8 Marquis Way.

Planning Ref AW/181/15/HH

I am writing to oppose the above planning application.

project:	11 Marquis Way - Aldwick		
drawing title:	Proposed Site Plan		
drawing status:	Planning Application		
date:	20 - 06 - 2015	scale at relevant drawing size 1 : 50 (A1) or 1 : 100 (A3)	no: JW131105 - PL10
rev:	B

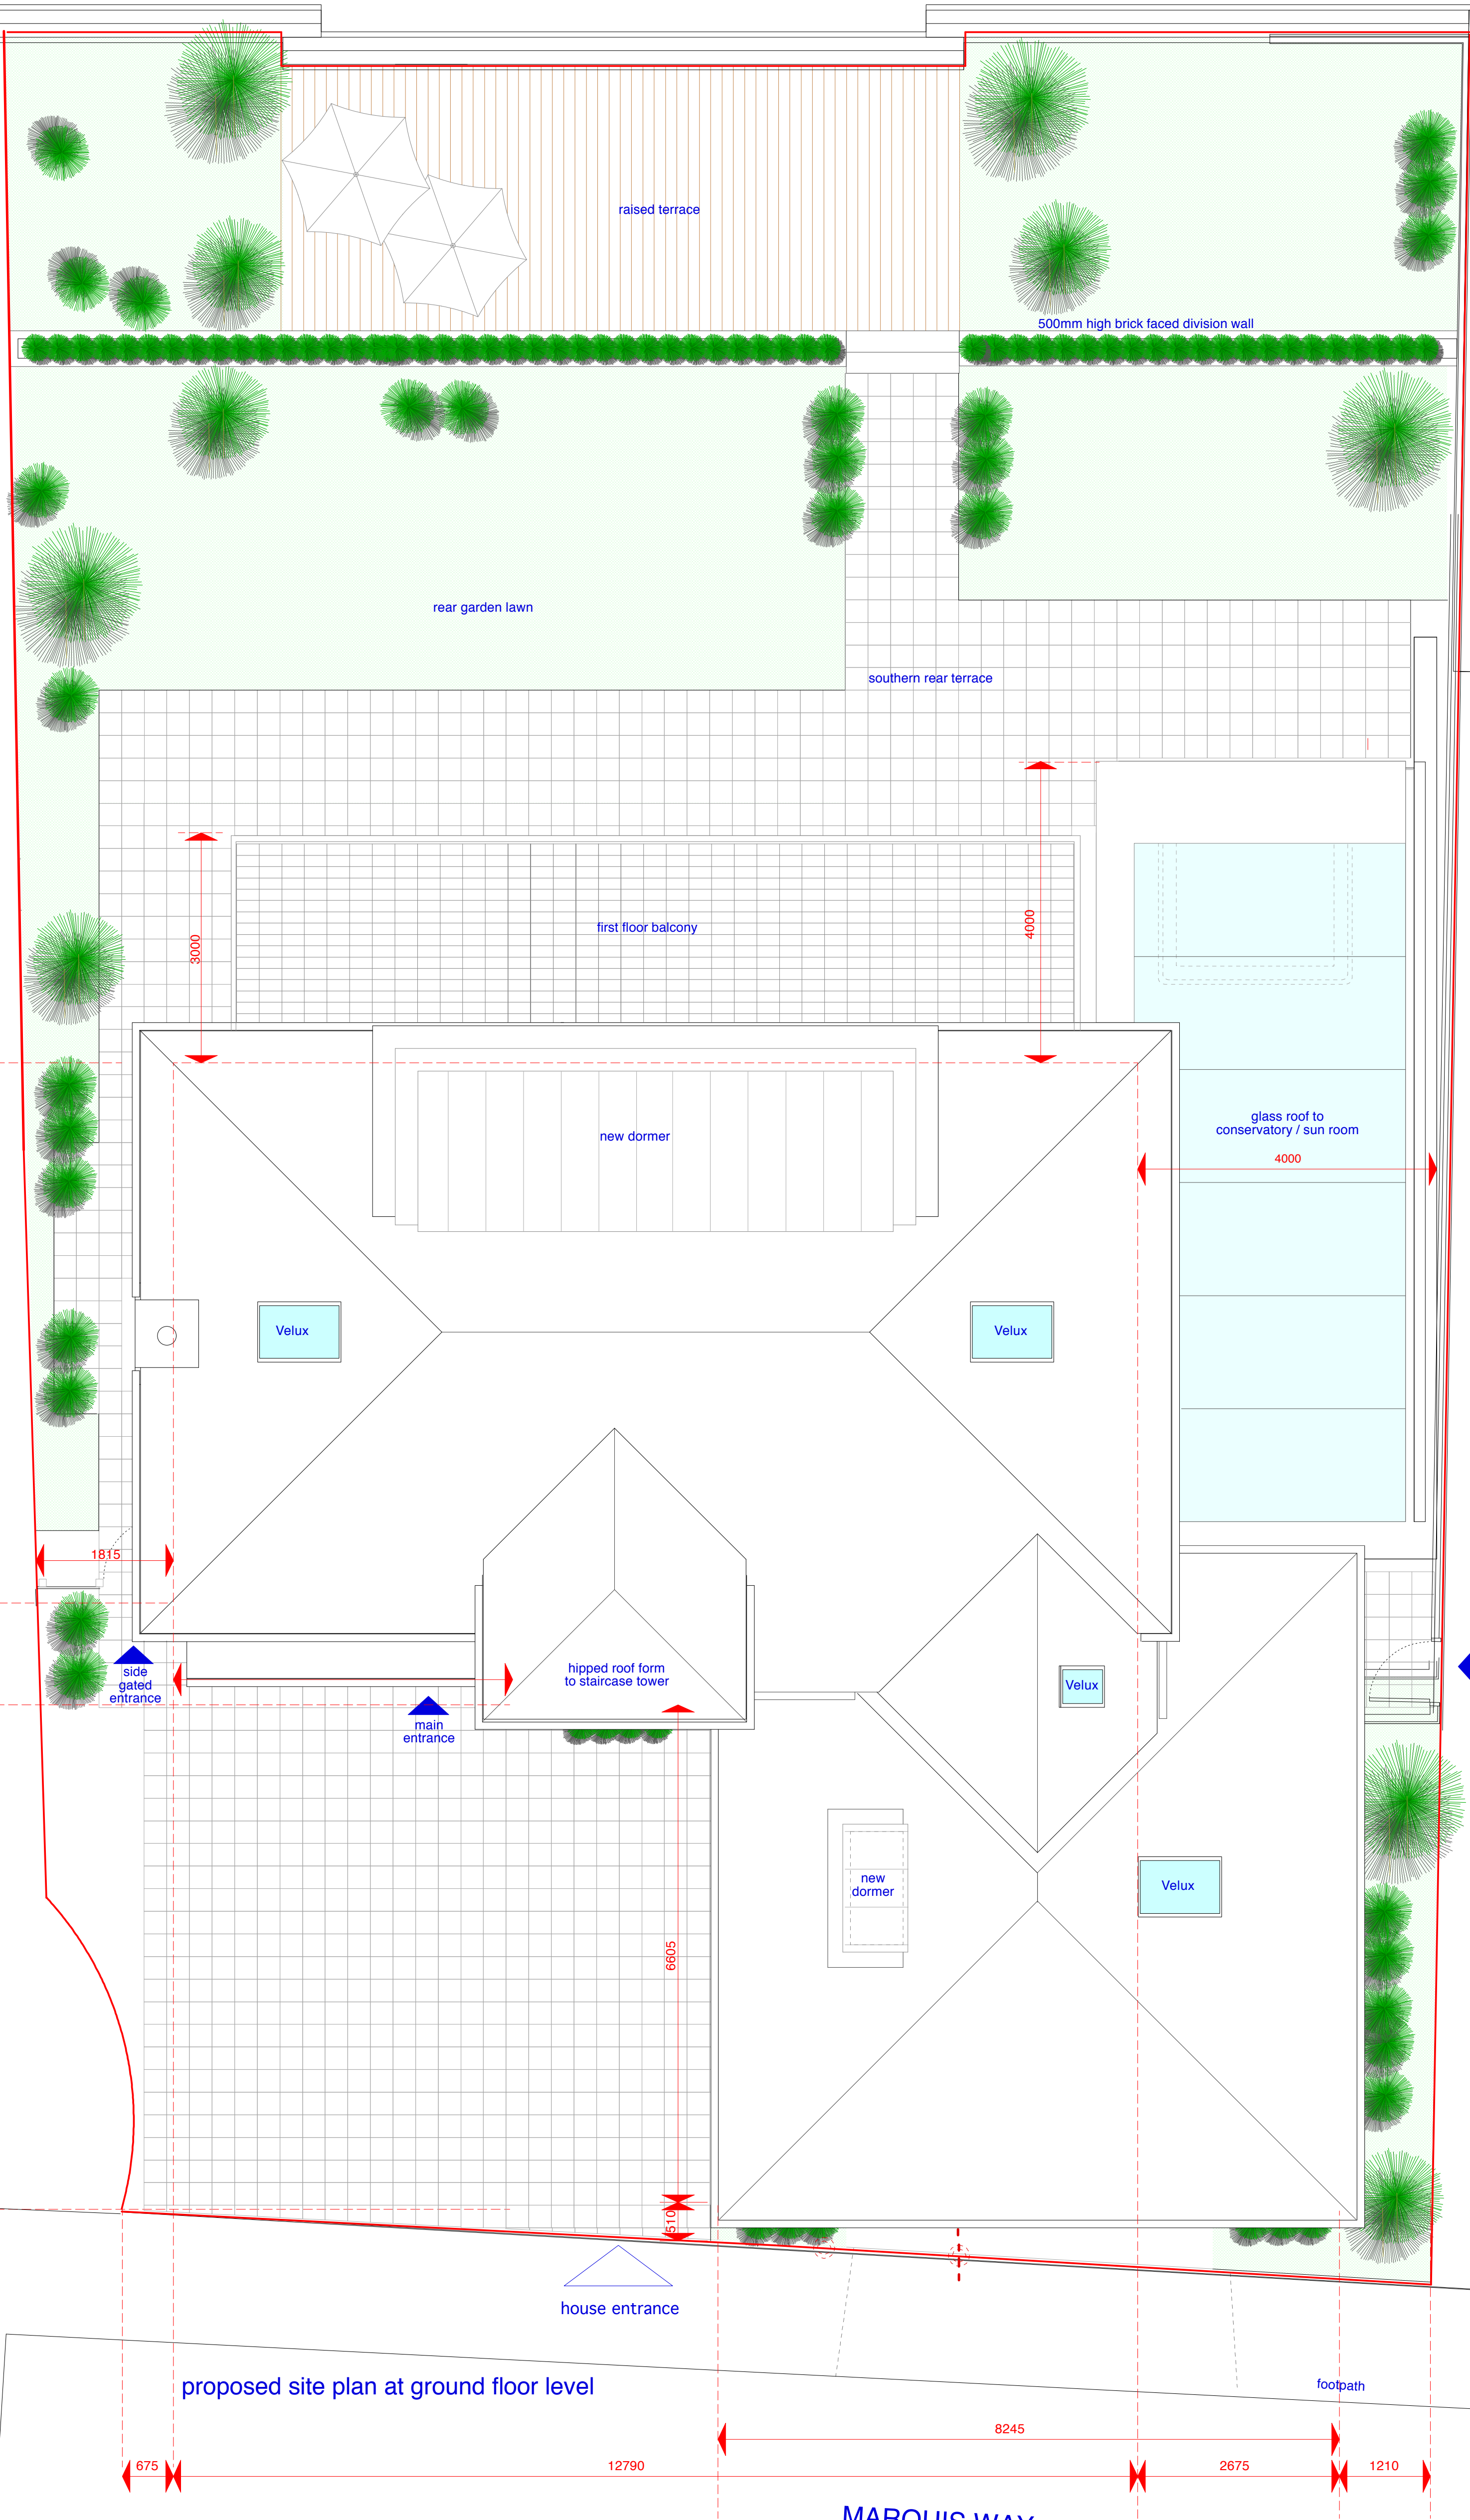
Under Arun's material planning effects, the design and appearance of the proposed building at No 11 is not sympathetic to current existing layout of the estate. It would negatively impact on the appearance of the area; and moreover under the Arun local plan Gen 7 section iv it would have an unacceptable adverse impact on adjoining properties. Also section Gen 7 section iii shows that the proposal doesn't respond positively to the identified characteristic of the estate and would not enhance our local distinctiveness.

Under Arun's 'specific type and forms of development' Dev 19 - the building doesn't sympathetically relate to existing building on the estate in design, form or materials. It will compromise the character and pattern of the street. It will have an adverse effect on the street scene and character of the area.

north elevation onto Marquis Way

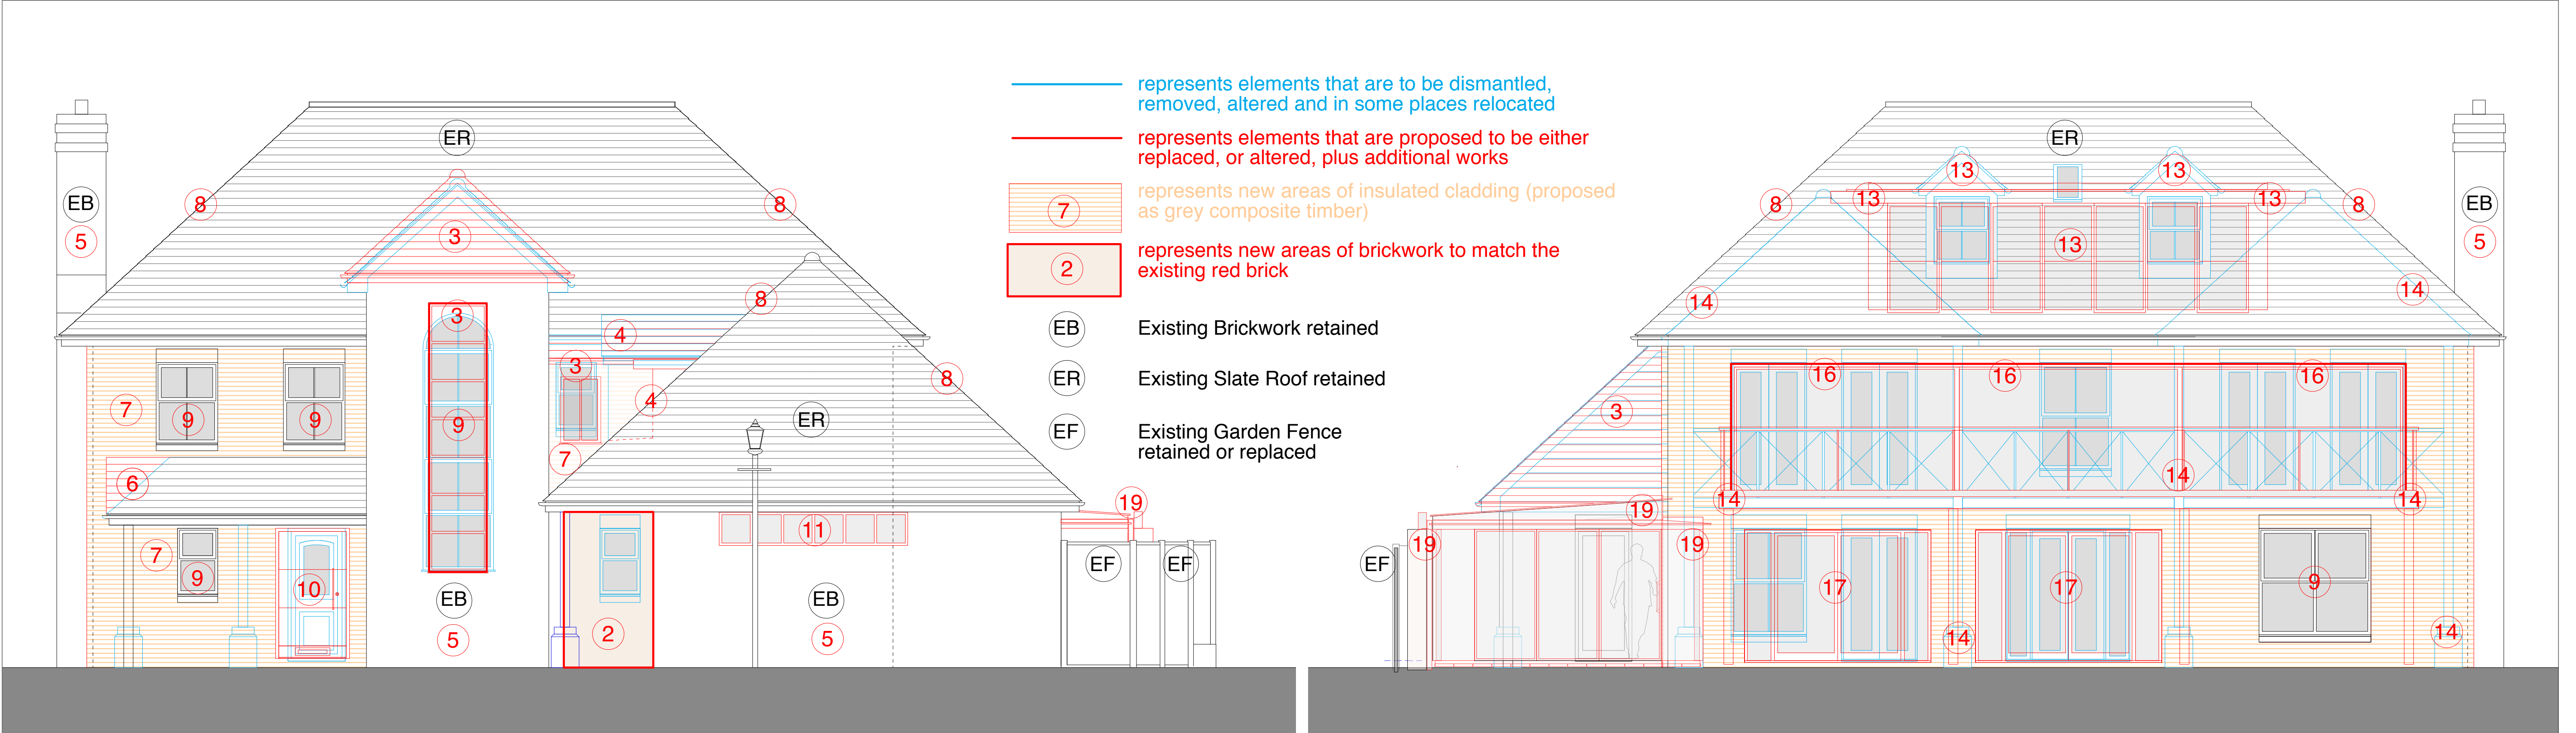
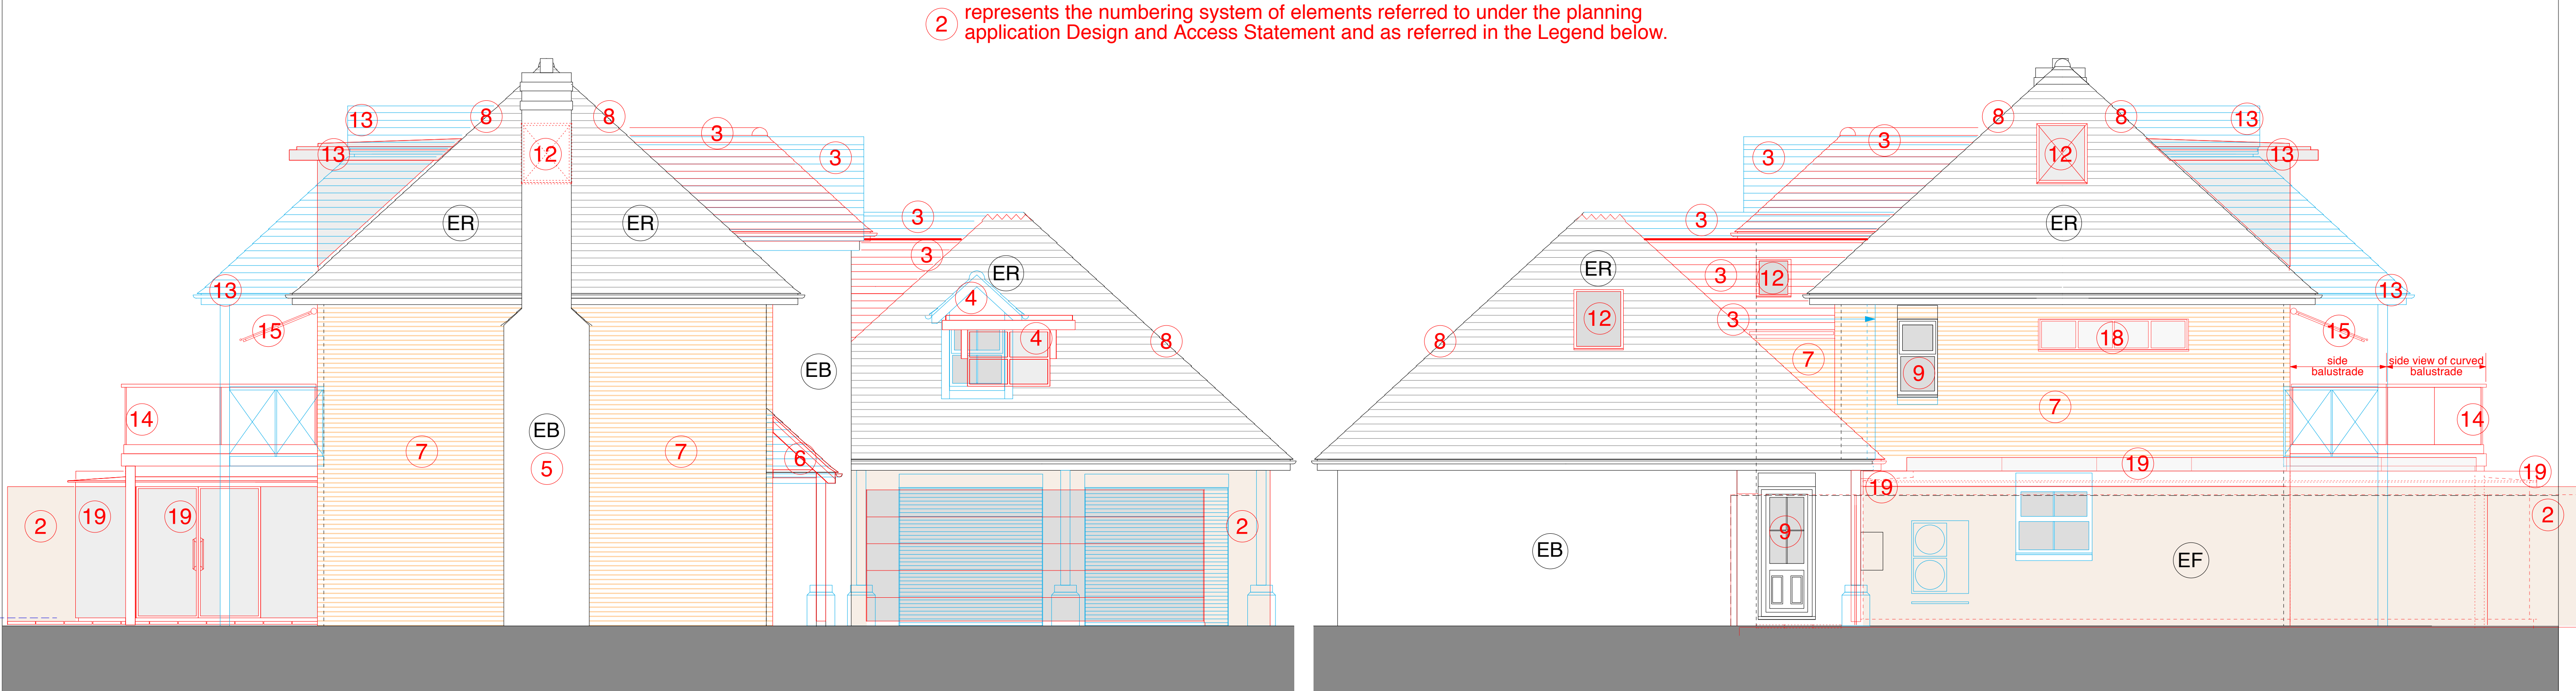
Thus far the planning history of our estate has shown that residents have a commendable commitment to keeping any alterations or extensions within an aesthetically pleasing manner, commensurate with the other properties. Indeed in my own case AW2/200/10 condition 3, material and finishes of external
